# LITTLE WALTHAM PARISH COUNCIL

Re: Longfield Solar Farm

I am contacting you on behalf of Little Waltham Parish Council. The Parish Council wishes the following submission to be taken into account in the examination of the application for the Longfield Solar Farm –

1:1000 @ A3

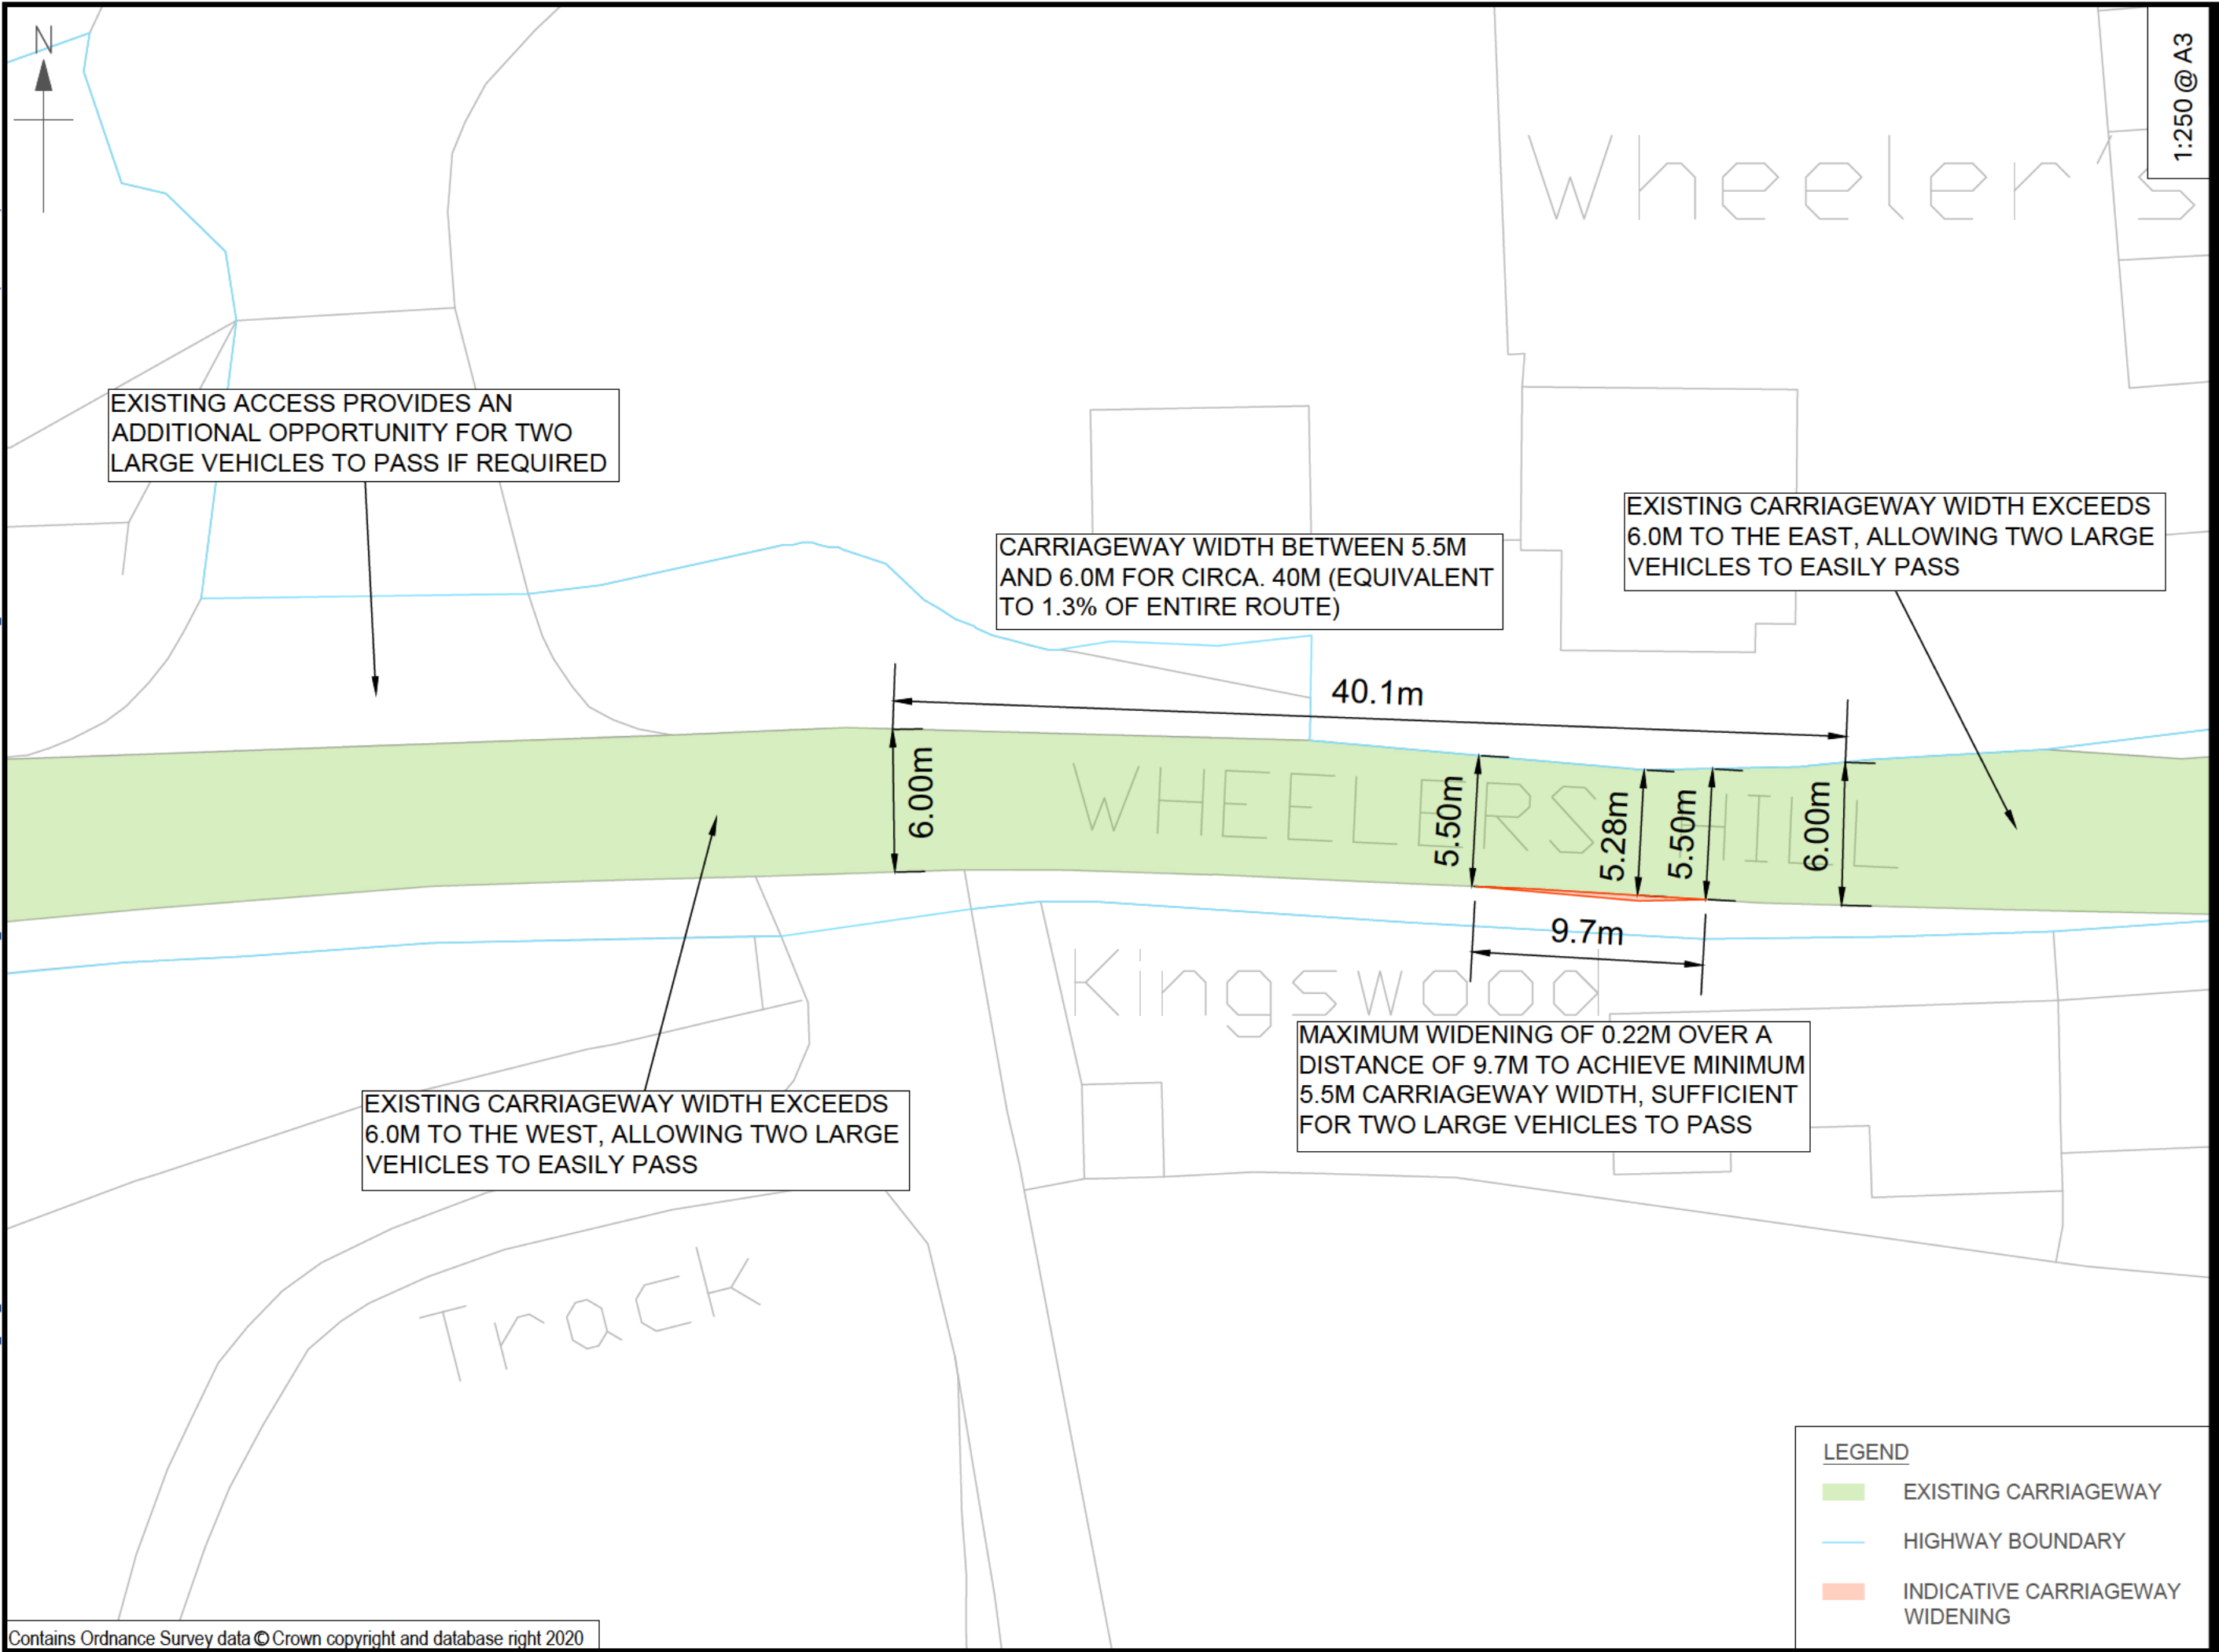
It is noted that the main access to the proposed solar farm would use Cranham Road.

The Parish Council wishes it to be noted that this road is a wholly inappropriate road to use to access the solar farm in its current condition.

The road is a narrow rural road that can barely accommodate existing traffic as evidenced by damage to the grass verges over recent years.

Therefore, unless work is carried out to the road to widen and improve it, then the Parish Council objects to Cranham Road being used as the main access to the site.
